Department of Planning and Environment

Our ref: DOC23/512994

Subject: Additional Information - Yiribana Logistics Estate (SSD-10272349)

Attachment 1: Environment and Heritage Group comments in relation Wianamatta–South Creek stormwater management targets for Yiribana Logistics Estate (SSD-10272349)

STORMWATER DRAINAGE MASTER PLAN
SCALE 1:1000

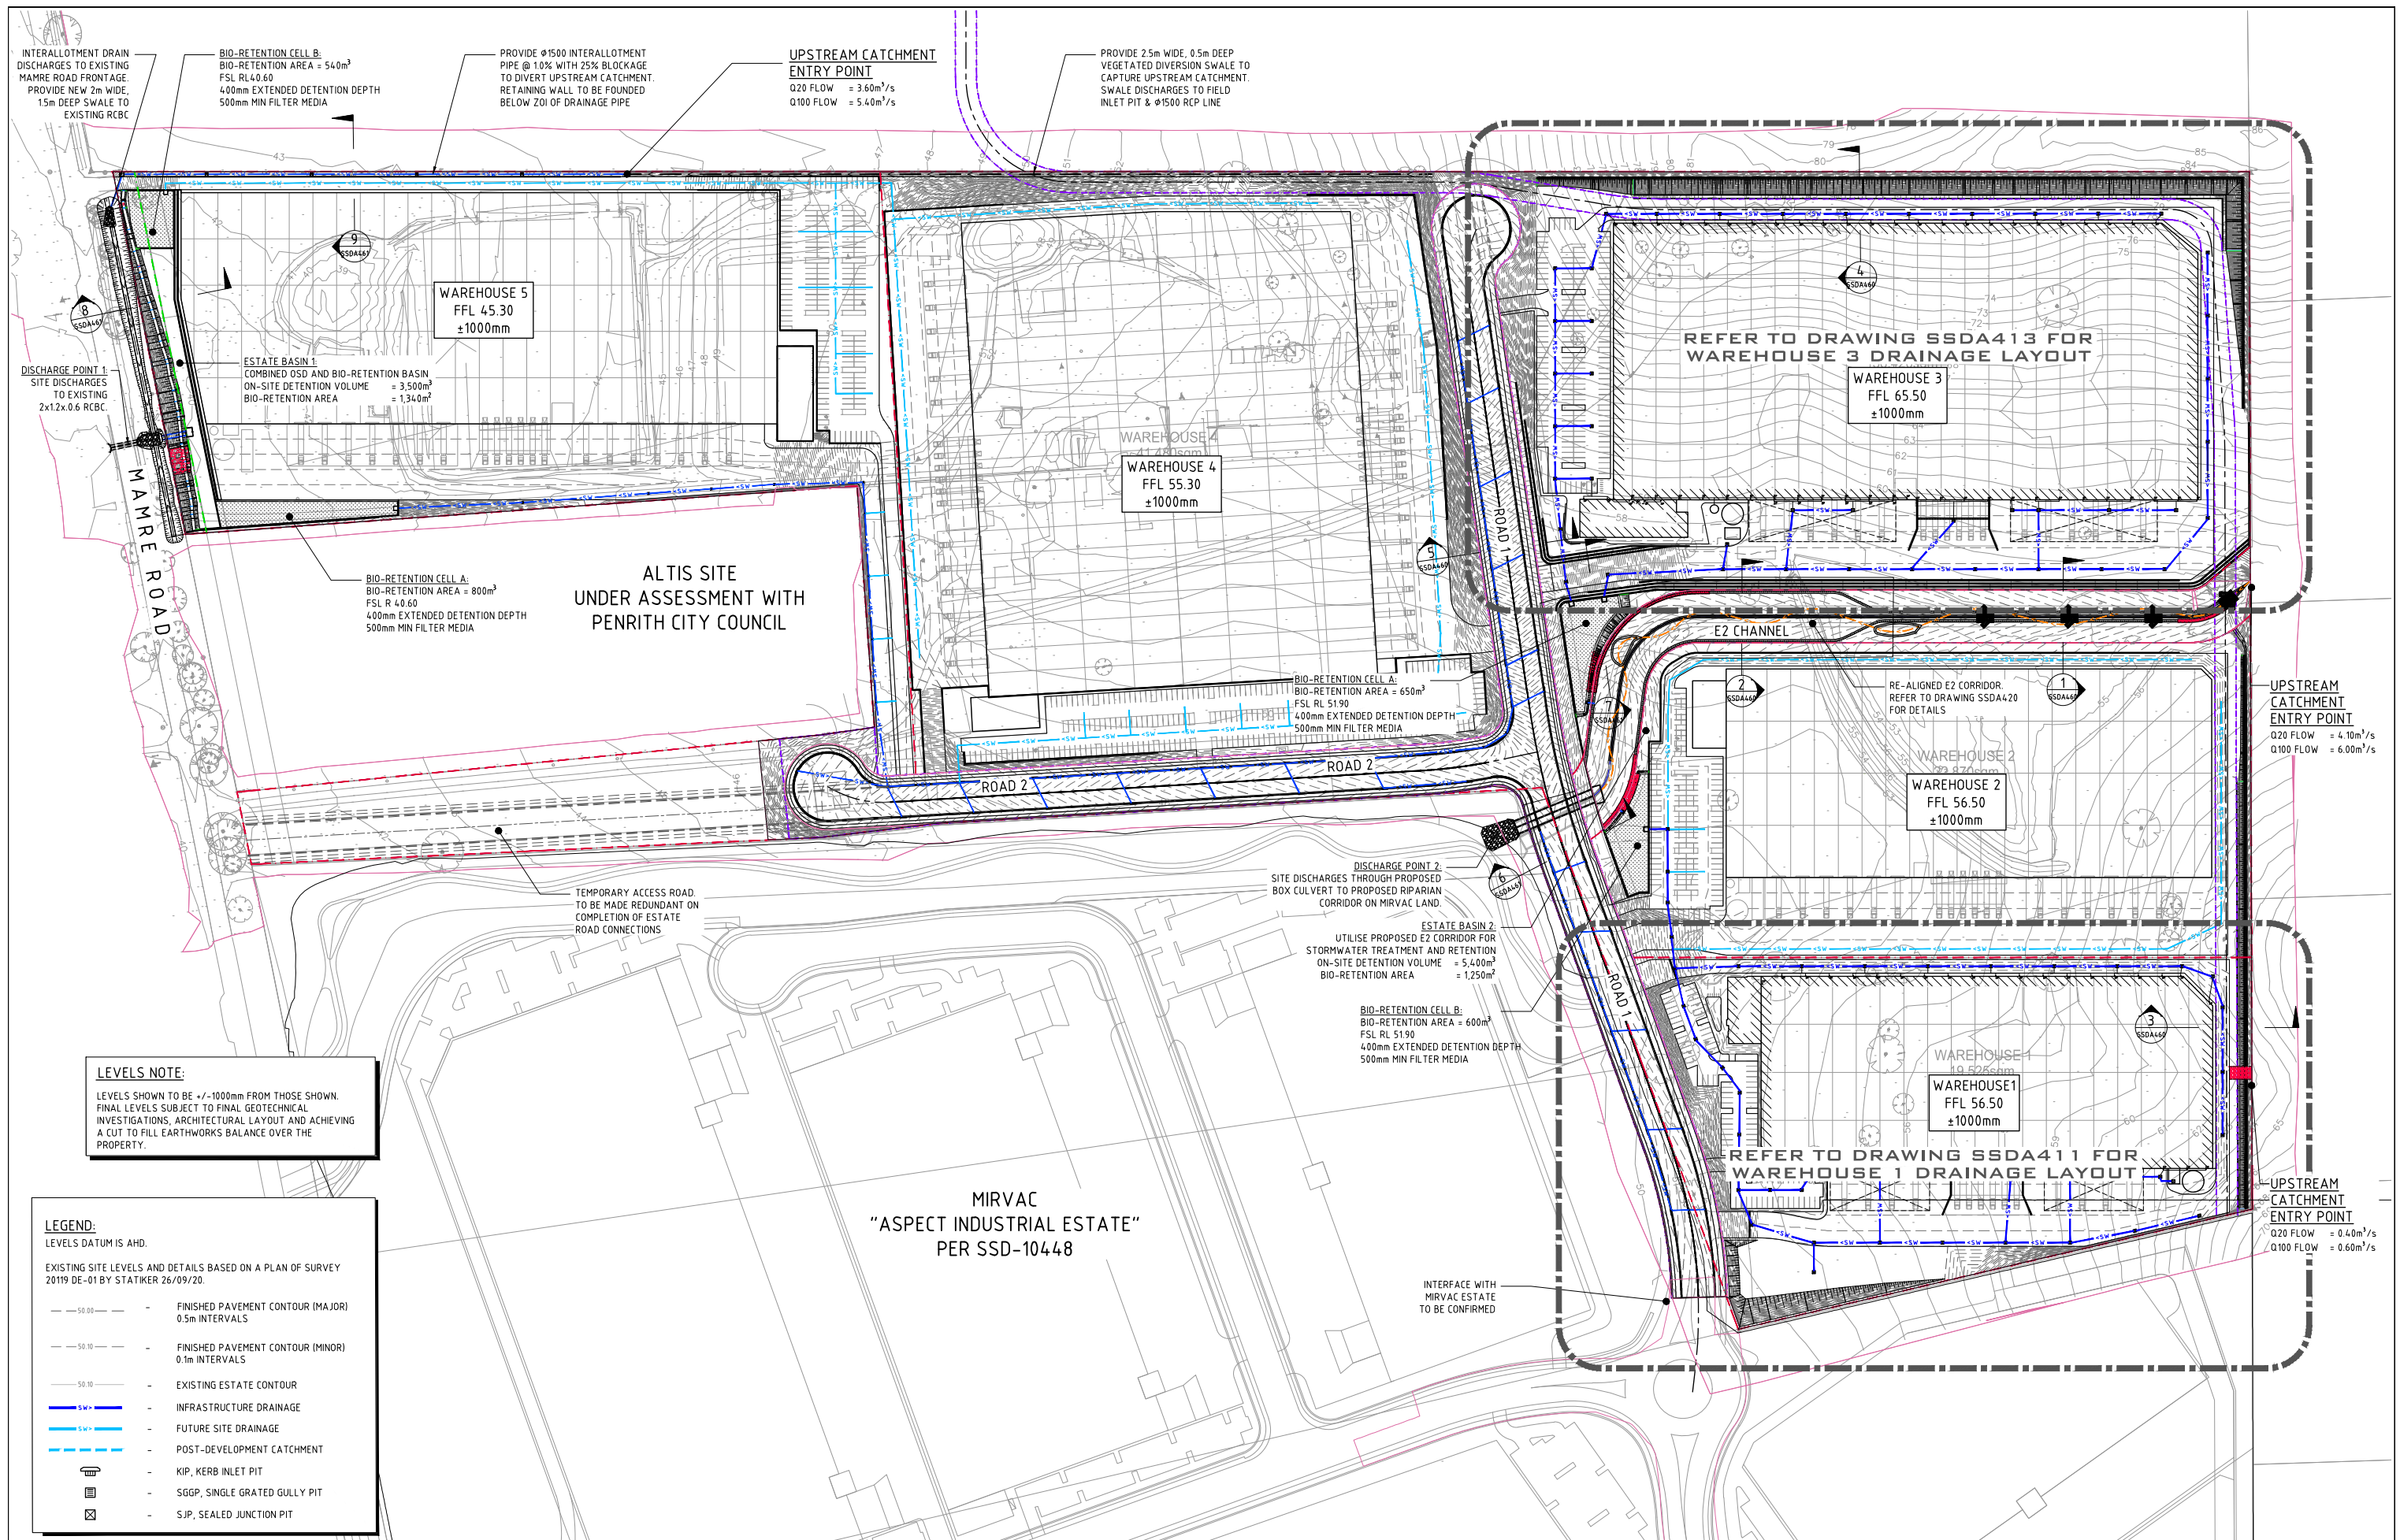
- The civil plans show field inlets connecting to an underground pipe system conflicting with the location proposed for the temporary swale used to convey catchment US2. Amend the plans to note that the underground system in this location is not to be commissioned until the temporary swale is no longer required (i.e., site to the east developed).

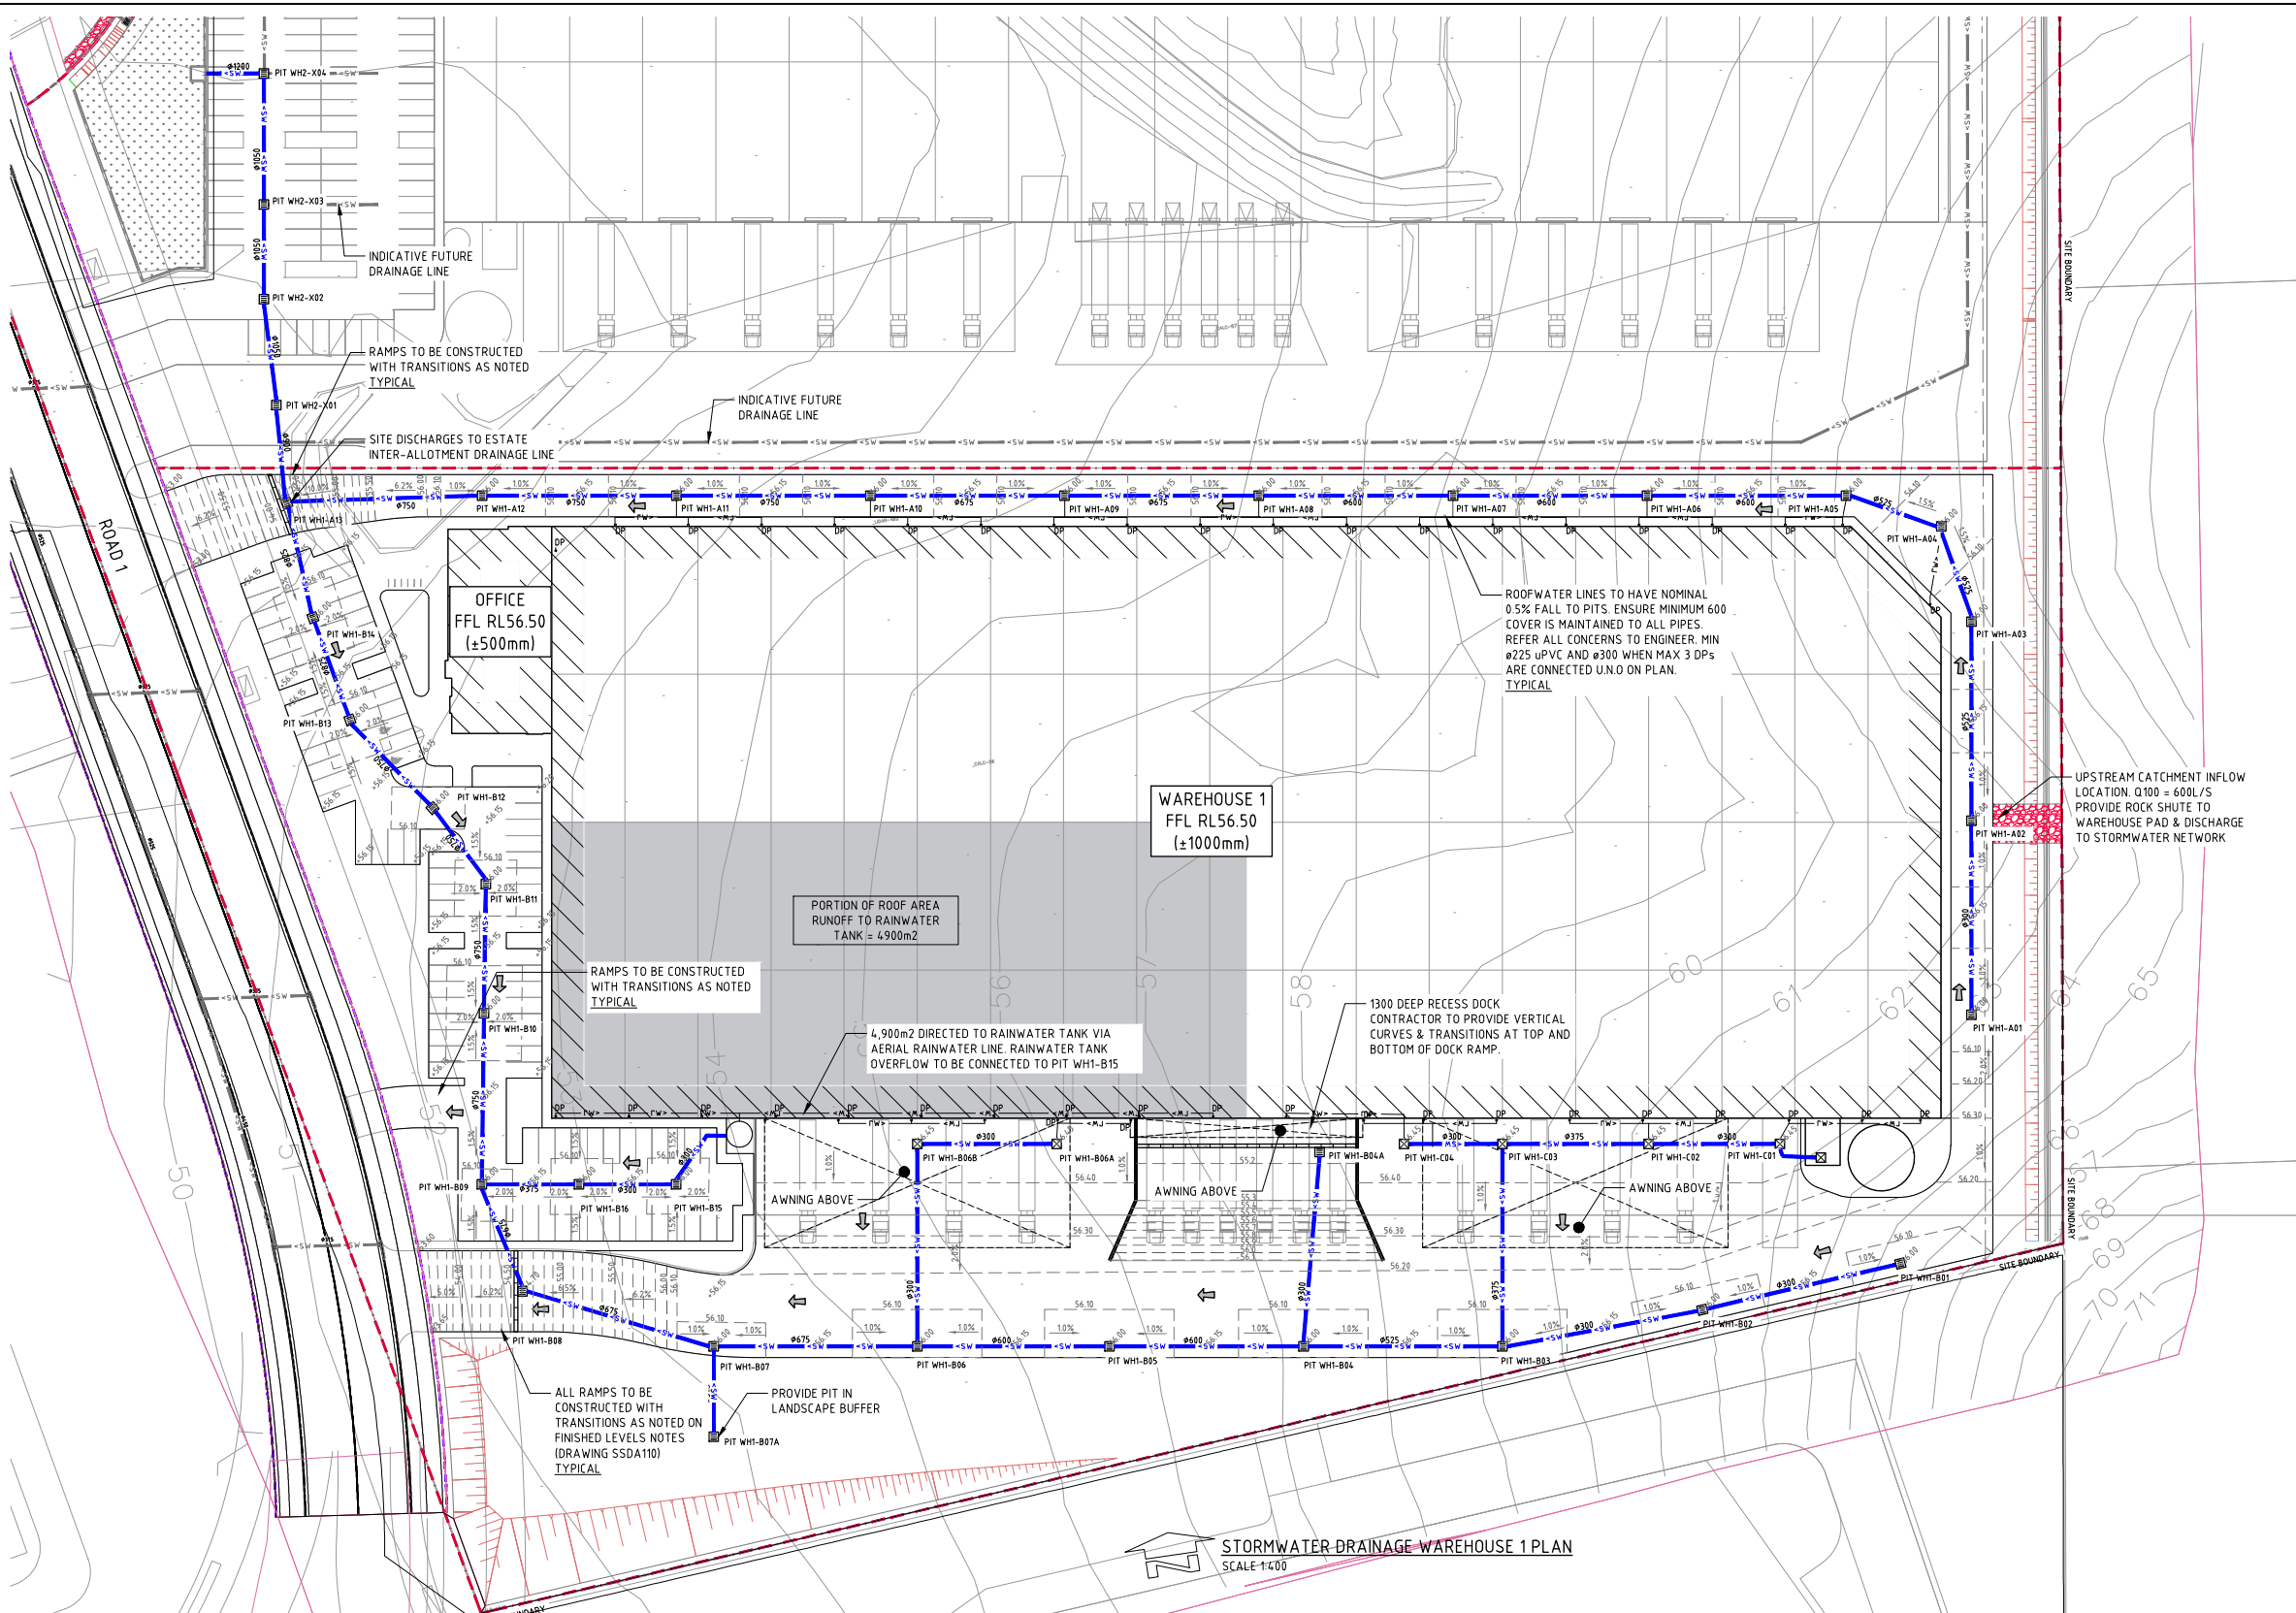
- The area to be irrigated by the Lot 3 reuse tank does not appear to be shown on Drawing SSDA405. Include a plan in the report which clearly shows all irrigation areas. These plans must be included in the report not as appendices amongst civil drawings.

- There are conflicting reuse rates for Lot 3 and Lot 1 and 2 reuse tanks, between that shown in Drawing SSDA405 and that applied in the MUSIC model. Ensure all reuse rates are in accordance with the Technical Guideline.
